11th March 2021

Application No: EP/16/21/PL
Site Address: Land East of 1 The Way East Preston BN16 1QJ
Description of works: Replacement garage. This site is in CIL Zone 4 (Zero Rated) as other development.

Thank you for your internet representation made on 10th March 2021 which has been recorded as support with the comments as follows:

Client: Mr D Lynch		
Project Address: The Garage The Way East Preston		
Drawing Title: Existing and Proposed Plans and Elevations		
Drawing Number: 1241.01.g		
Scale:	As stated printed @ A1	
Date:	06/01/2020

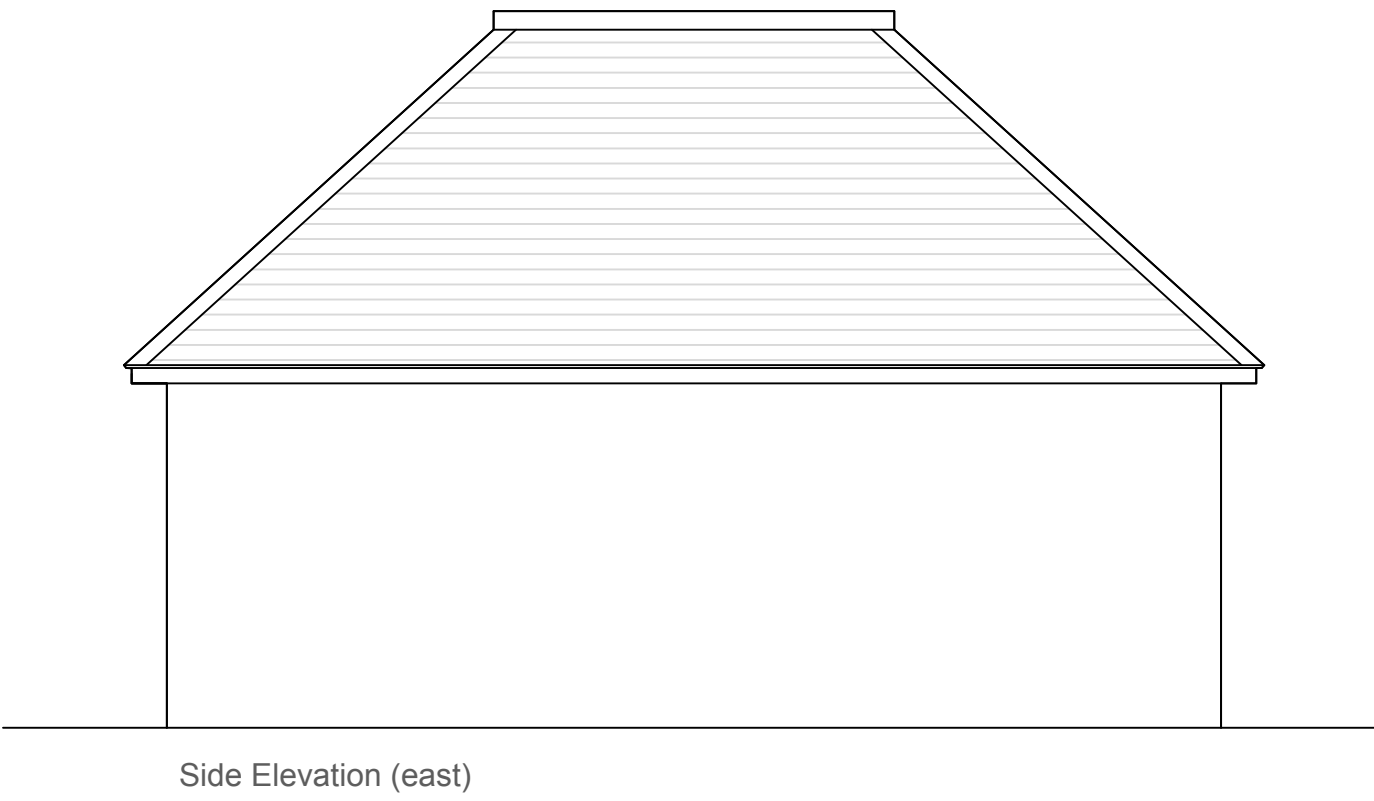
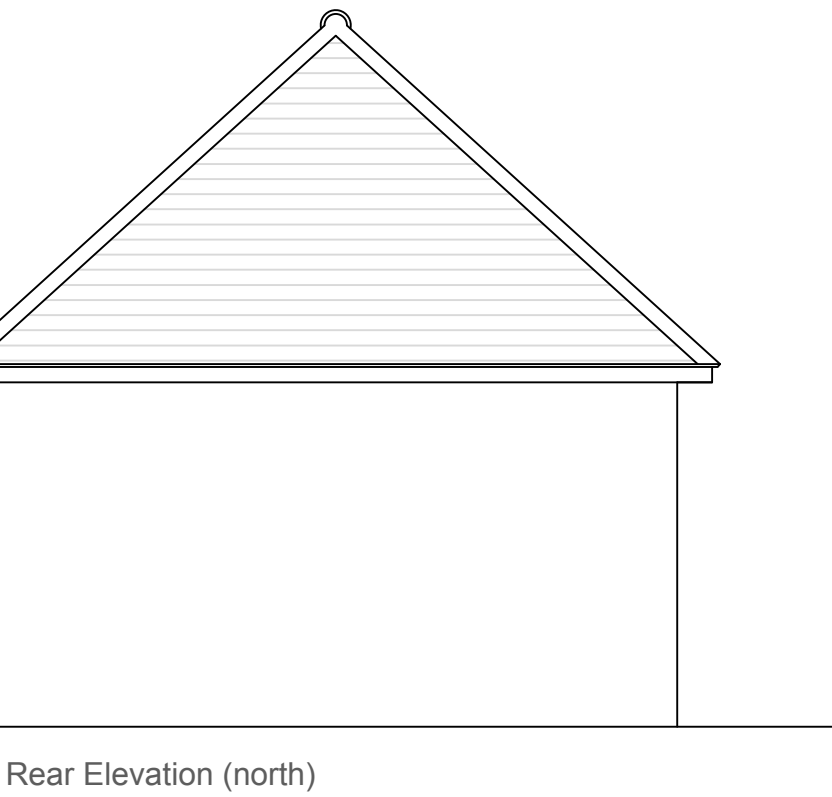
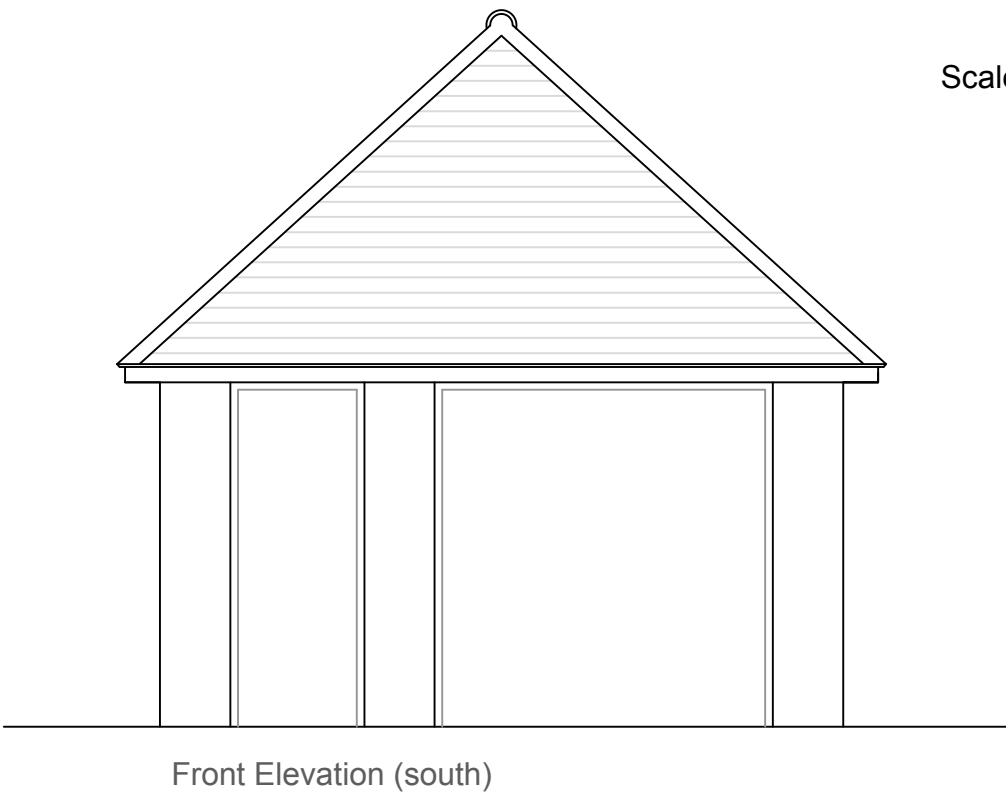
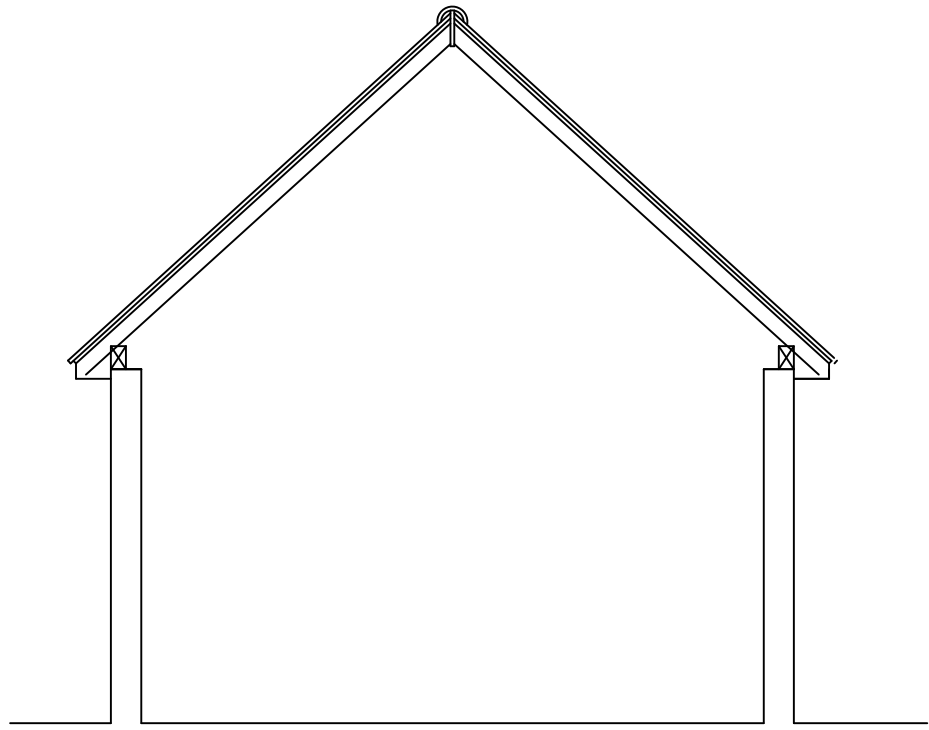
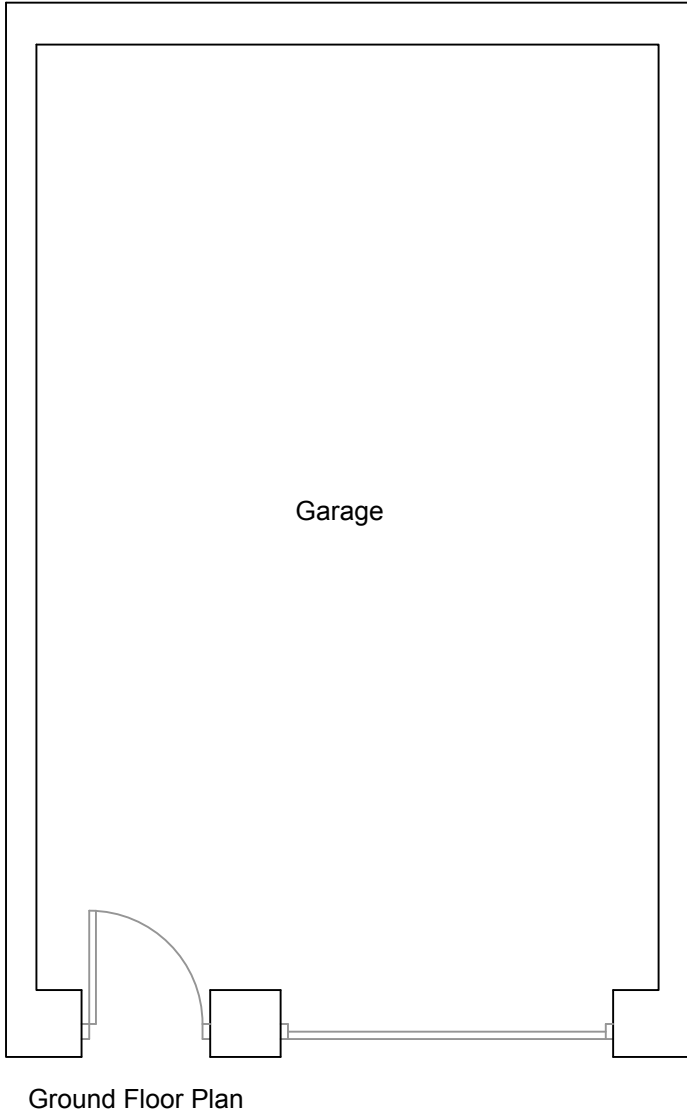
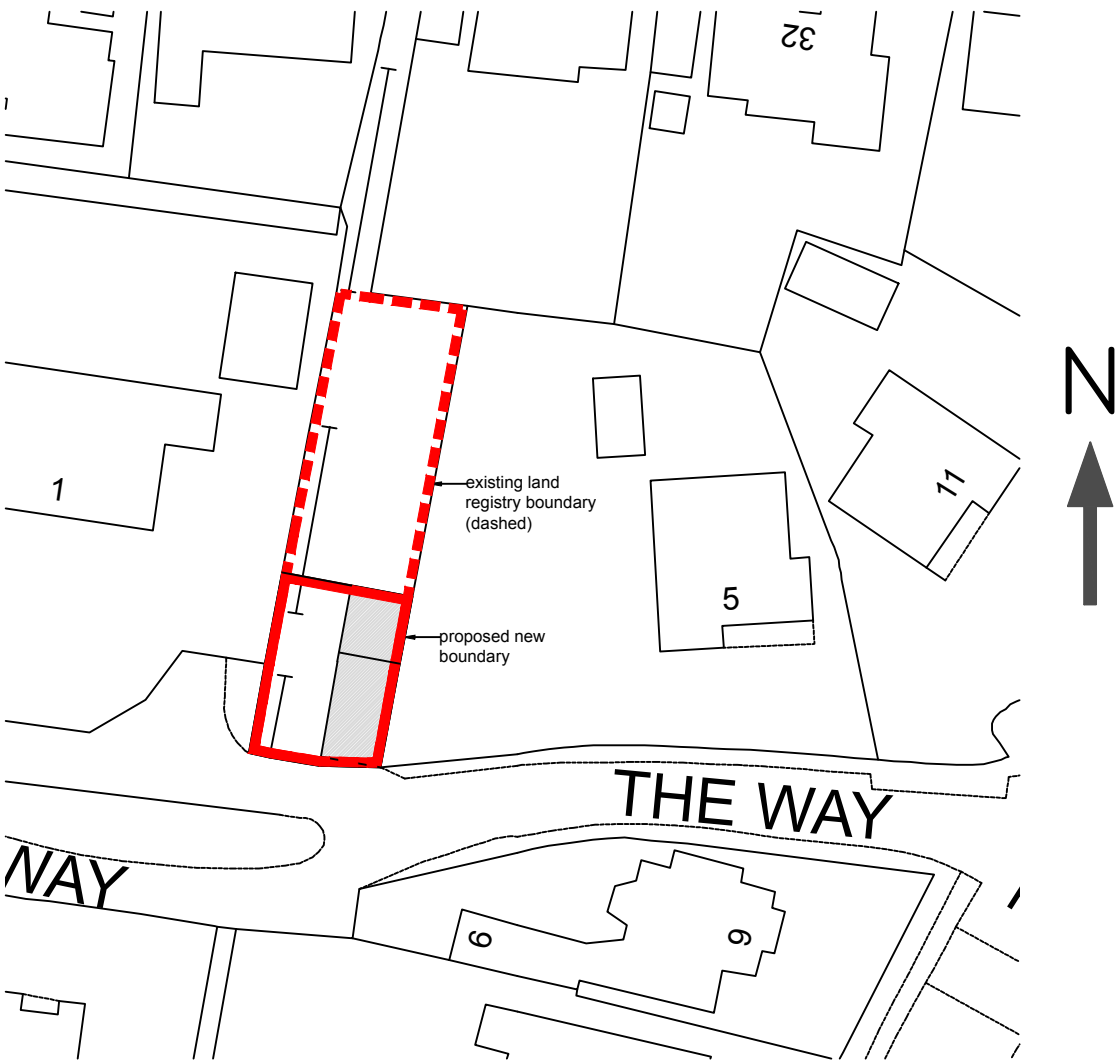
As the neighbour with the most direct view of the development, I do not believe it would be overbearing nor have an excessive impact on our enjoyment of our garden. In this respect I applaud the 'catslide' roofline and the efforts made on the appearance of the exterior with the combination of render and 'quoining' (?) echoing developments elsewhere in the village.

In summary, the proposed design is perhaps not as I would have chosen, I would of course prefer fewer rooflights and a lower roof line. But I believe the application is quite reasonable and not out of keeping with other developments seen in the village and the immediate vicinity over recent years.
